Re: Amerstone Town Homes #1, 915 Edith Blvd. NE, Traffic Circulation Layout
Architect's Stamp dated 9-22-08 (J15-D093)

The TCL submittal received 9-23-08 is approved for Building Permit. The plan is stamped and signed as approved. A copy of this plan will be needed for each of the building permit plans. Please keep the original to be used for certification of the site for final C.O. for Transportation. **Public infrastructure or work done within City Right-of-Way shown on these plans is for information only and is not part of approval. A separate DRC and/or other appropriate permits are required to construct these items.**

TCL / Site Plan

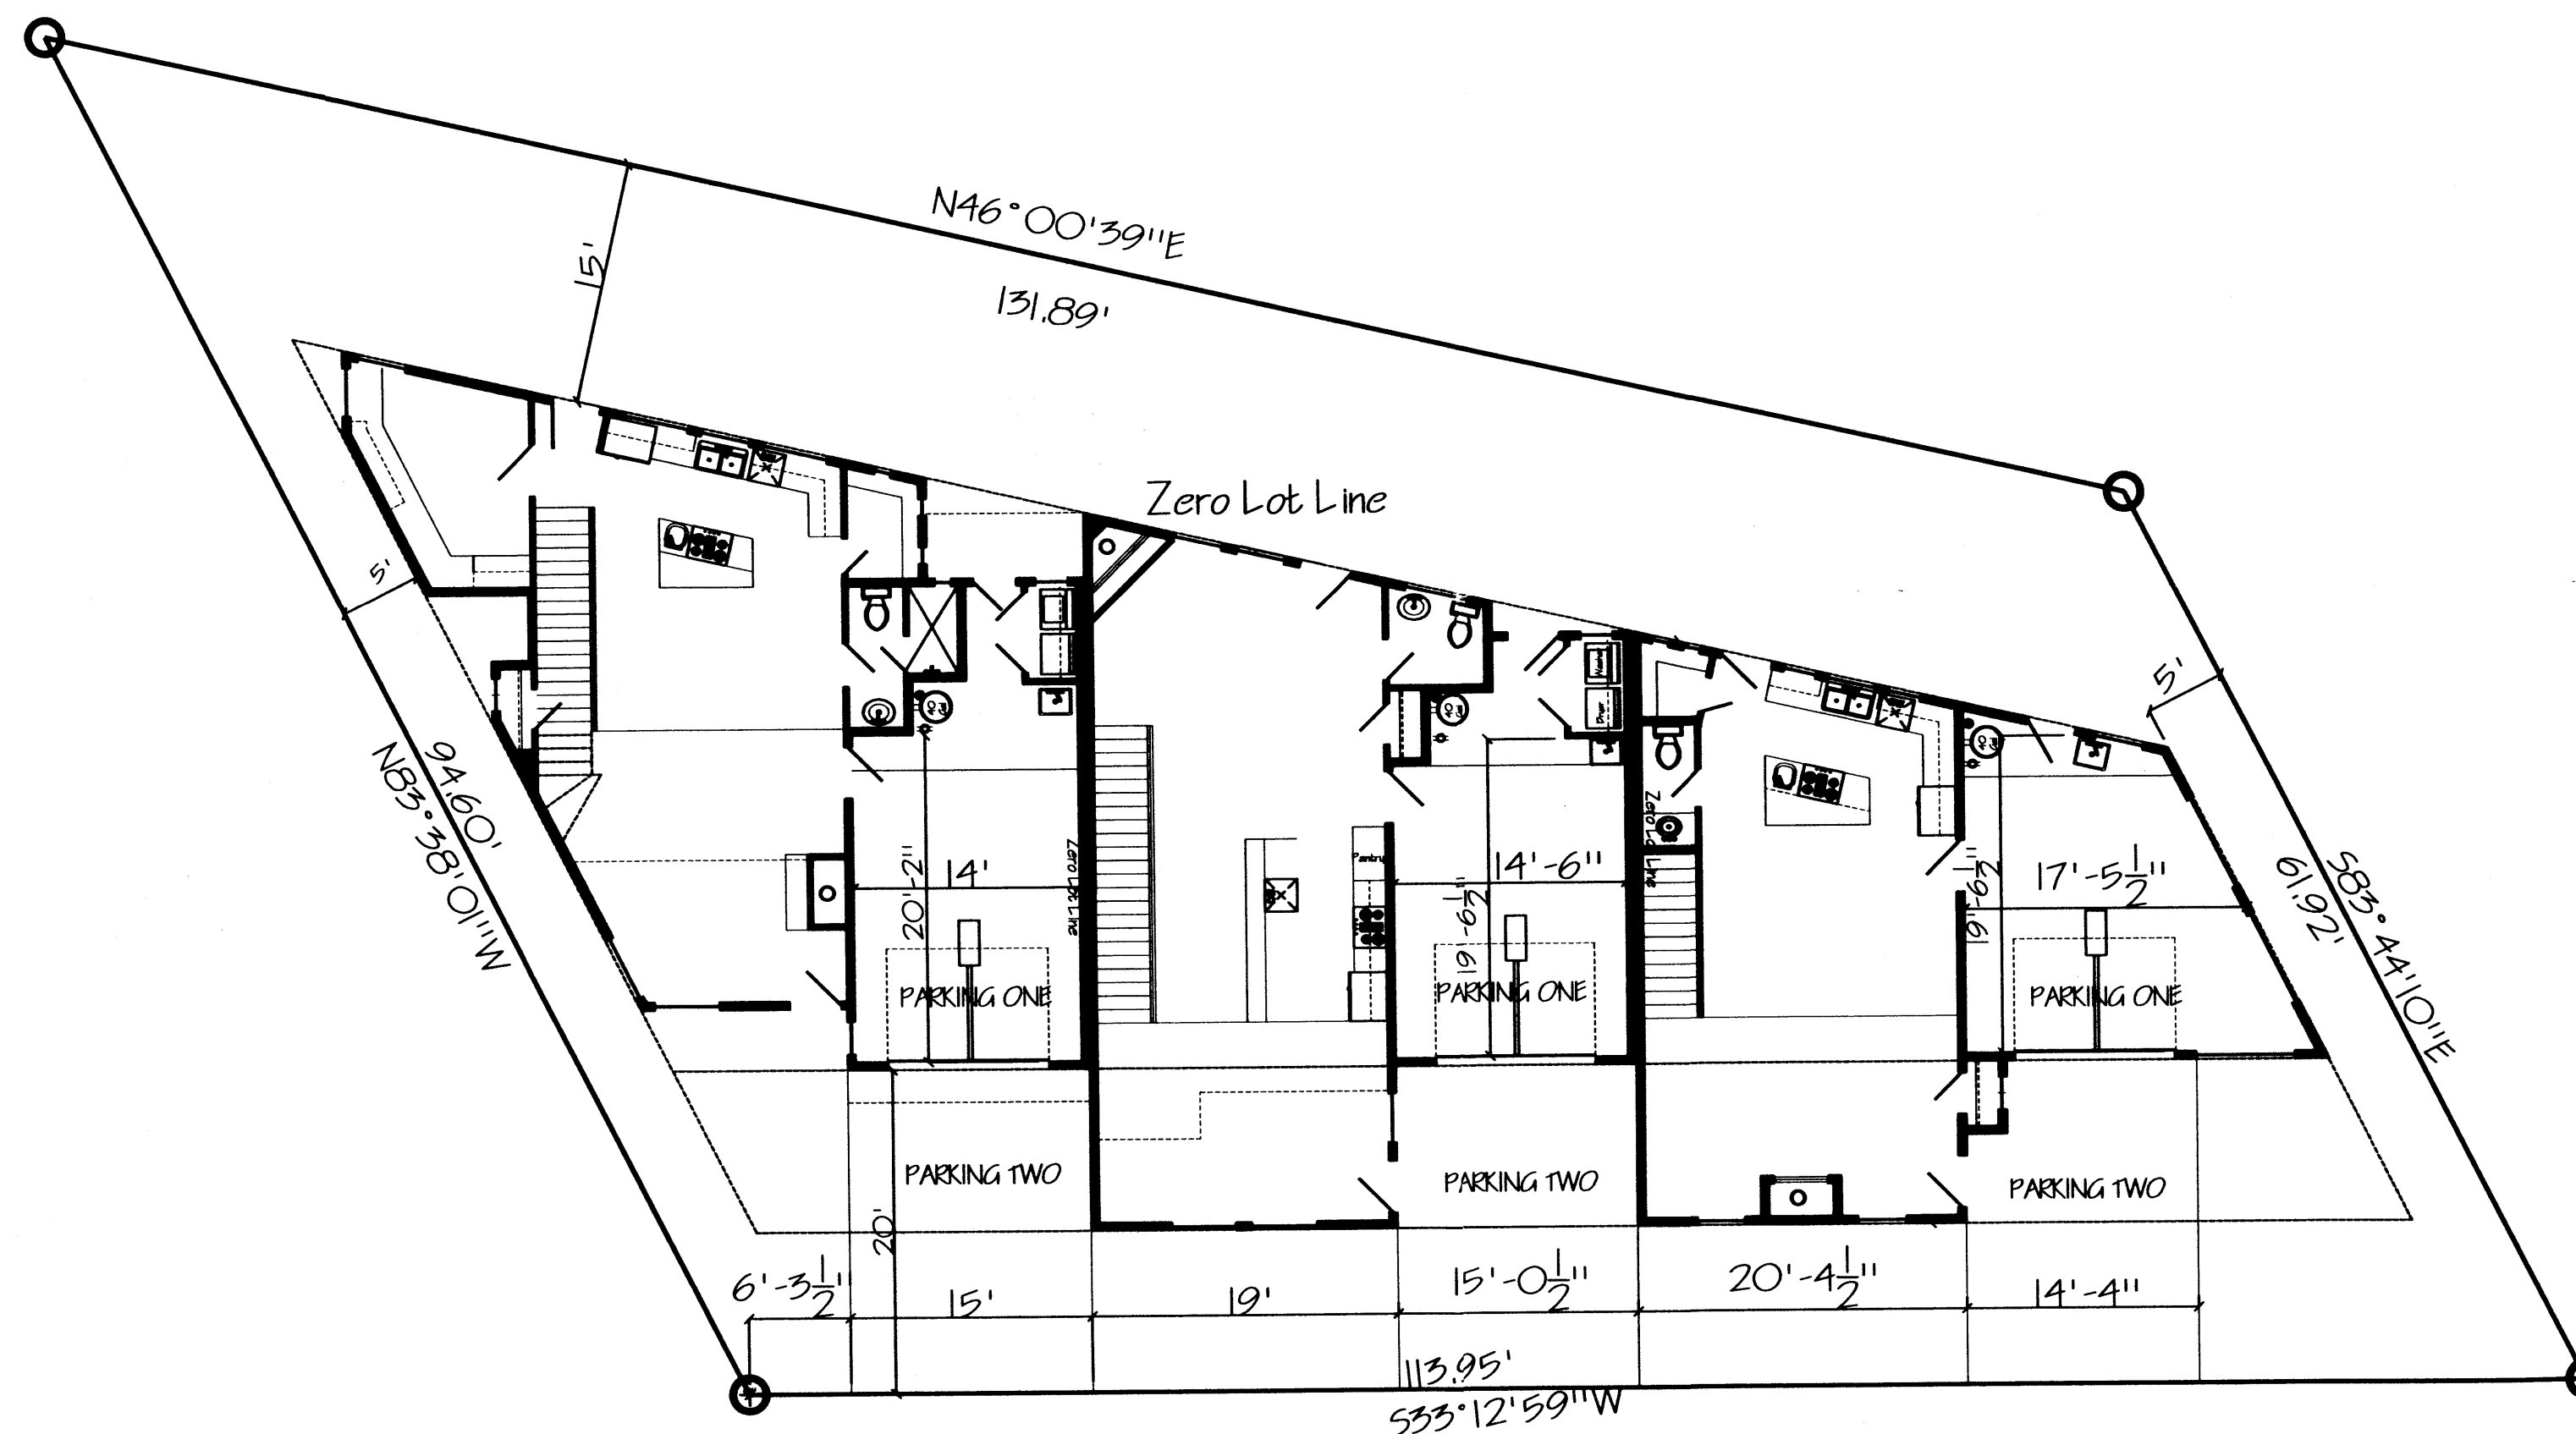
- The current scale does not appear to be accurate. Please provide the appropriate scale, preferably 1:10 or 1:20. Per the *Development Process Manual*, Chapter 27, Section 7, Part F.II, a scale of 1"=20' is recommended for sites of less than 5 acres.

1. The current scale does not appear to be accurate. Please provide the appropriate scale, preferably 1:10 or 1:20. Per the *Development Process Manual*, Chapter 27, Section 7, Part F.II, a scale of 1"=20' is recommended for sites of less than 5 acres.
2. Include the site's legal description on the plans.
3. The shading shown on this plan does not allow for the necessary information to be provided. What is the purpose of this shading? Is this area a proposed garage? Driveway? Please clarify.

- ✓1. The traffic circulation layout (TCL) must be stamped, signed, and dated by an engineer or architect licensed in the state of New Mexico.
- ✓2. Provide parking calculations per the City of Albuquerque Zoning Code. Include the calculation worksheet on the TCL.

3. Dimension all parking areas and clarify their location.
- ④. Per the Development Process Manual, Chapter 27, Section 2, Part B.1, only the following scales may be used:

- 1" = 50'
 - 1" = 40'
 - 1" = 20'
 - 1" = 10'
 - 1" = 100' (for overall layouts only)
- ✓5. Clarify all lot lines; the plan states "Zero Lot Lines," but at the top of the page there is a conflicting note stating "Minimum 10' between buildings." Which note applies; which note will be enforced?

- ✓6. What is the exact width of Edith Blvd? Will this site have median access, or will this site have right in and right out access only?
- ✓7. The vicinity map is unclear. Where is the exact location of the site? Provide a more legible vicinity map showing the exact location. Include the legal description of the site.

- ✓8. Where is north on the plan? Please include a north arrow.

CITY OF ALBUQUERQUE, BERNALILLO COUNTY				NEW MEXICO	
TRACT A LANDS OF CHRIS CHAVEZ					
AMERSTONE TOWNHOMES GRADING & DRAINAGE PLAN

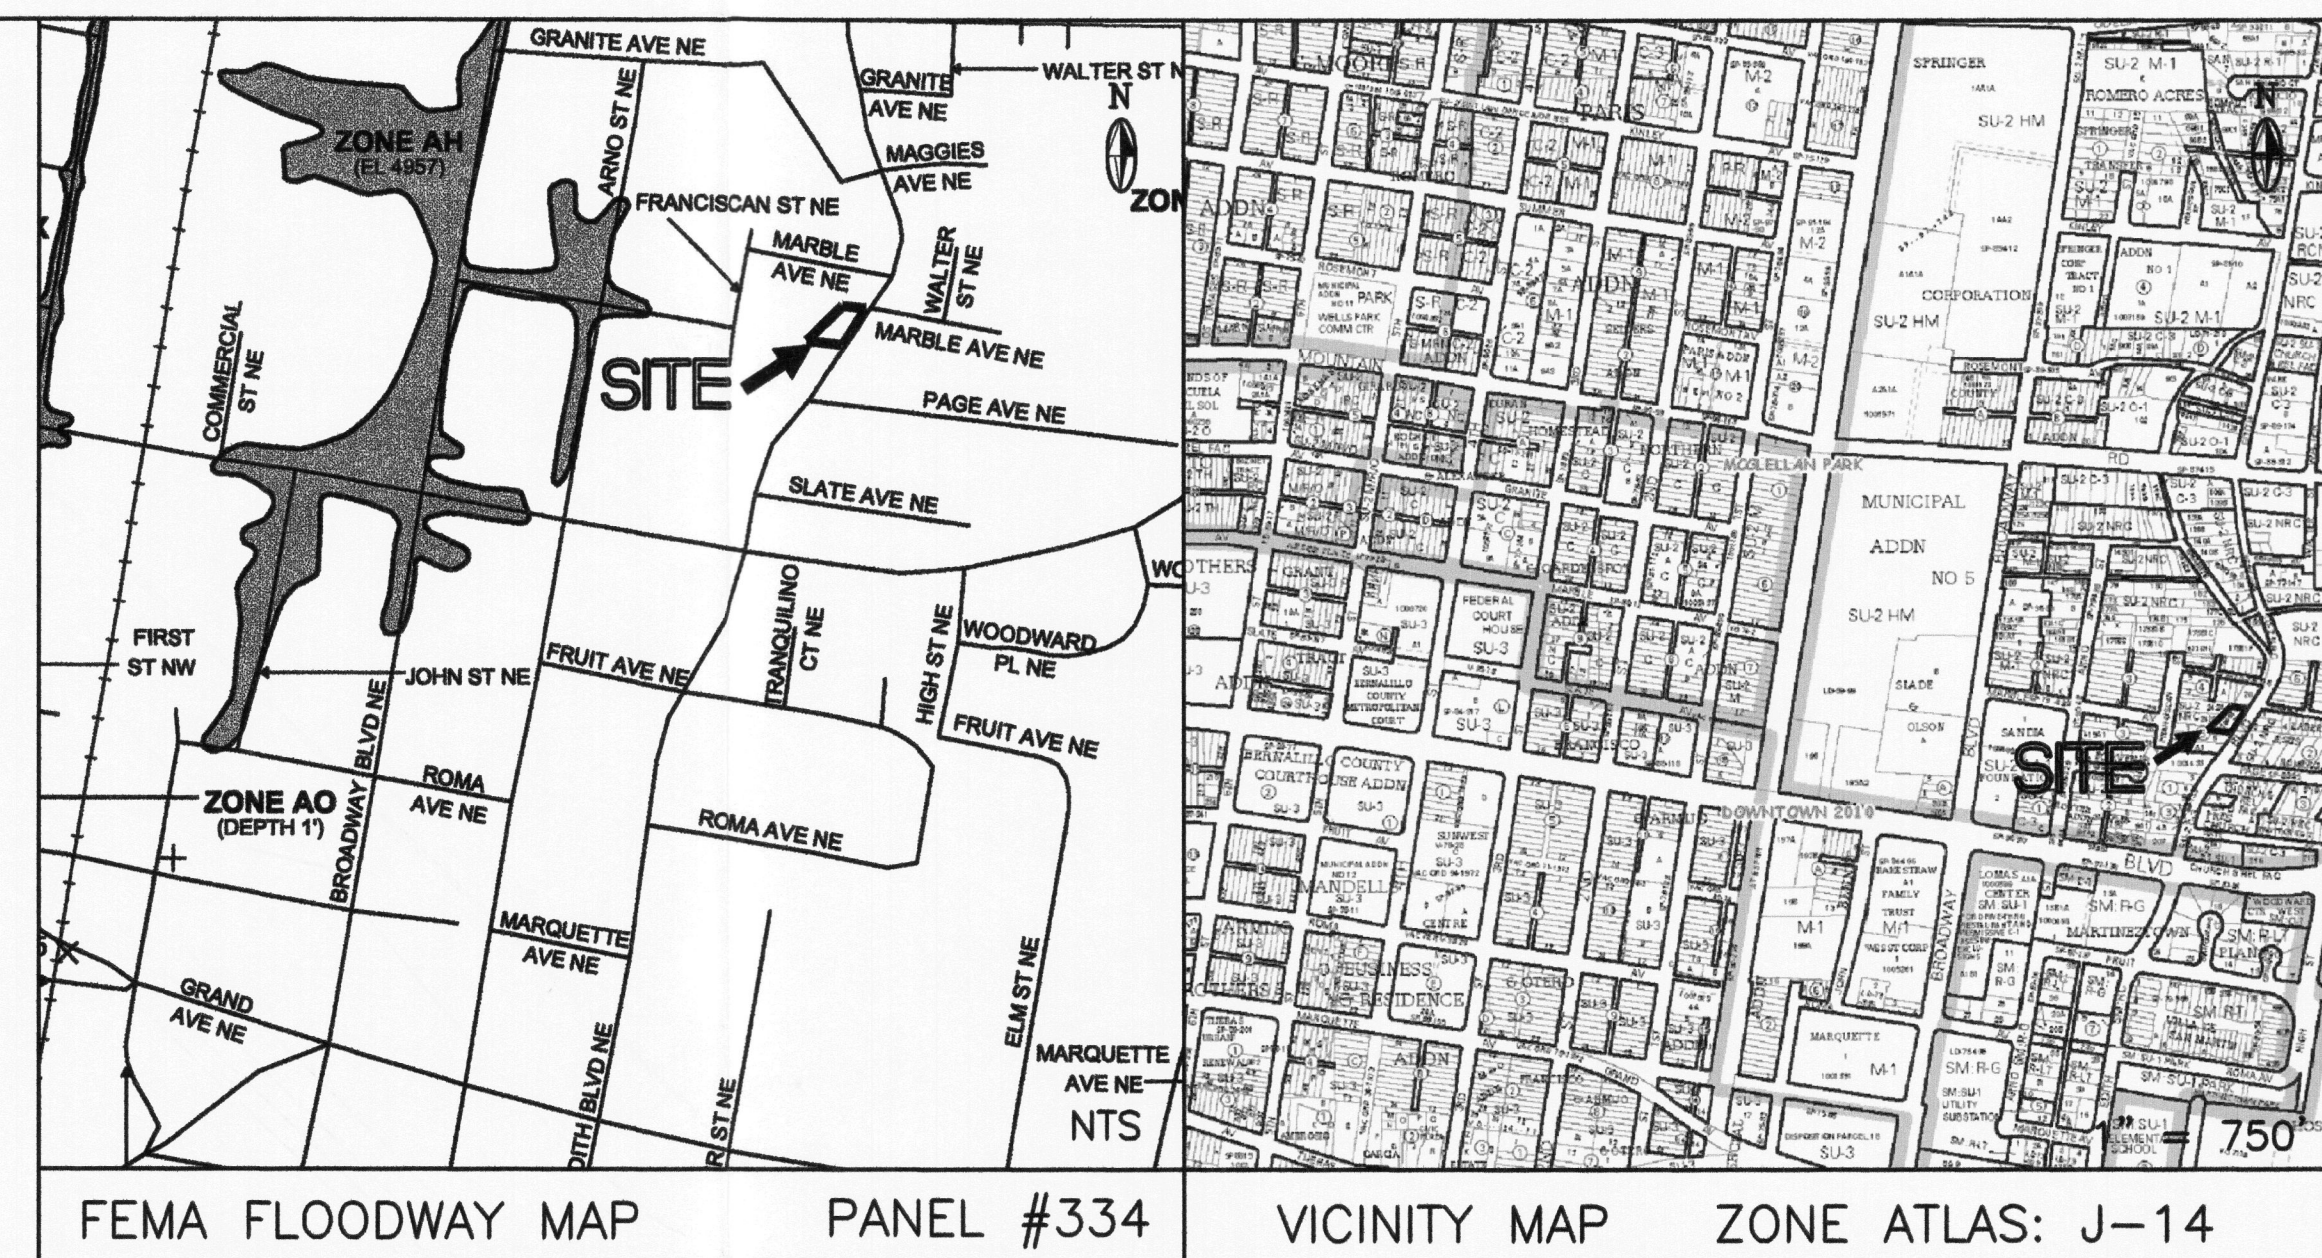
- Hydrology needs a minimum 6"(inch) freeboard from water surface elevation and top of wall.
- You'll need to specify on plans a water proofing treatment for proposed retaining wall.

- Provide spot elevations around the perimeter of the building (front and back).
- Water surface elevation for proposed pond will need to be provided.

- The wall has been adjusted to provide a 6" freeboard from the water surface elevation and top of wall.
- It has been specified on the plan for water proofing treatment along the wall.
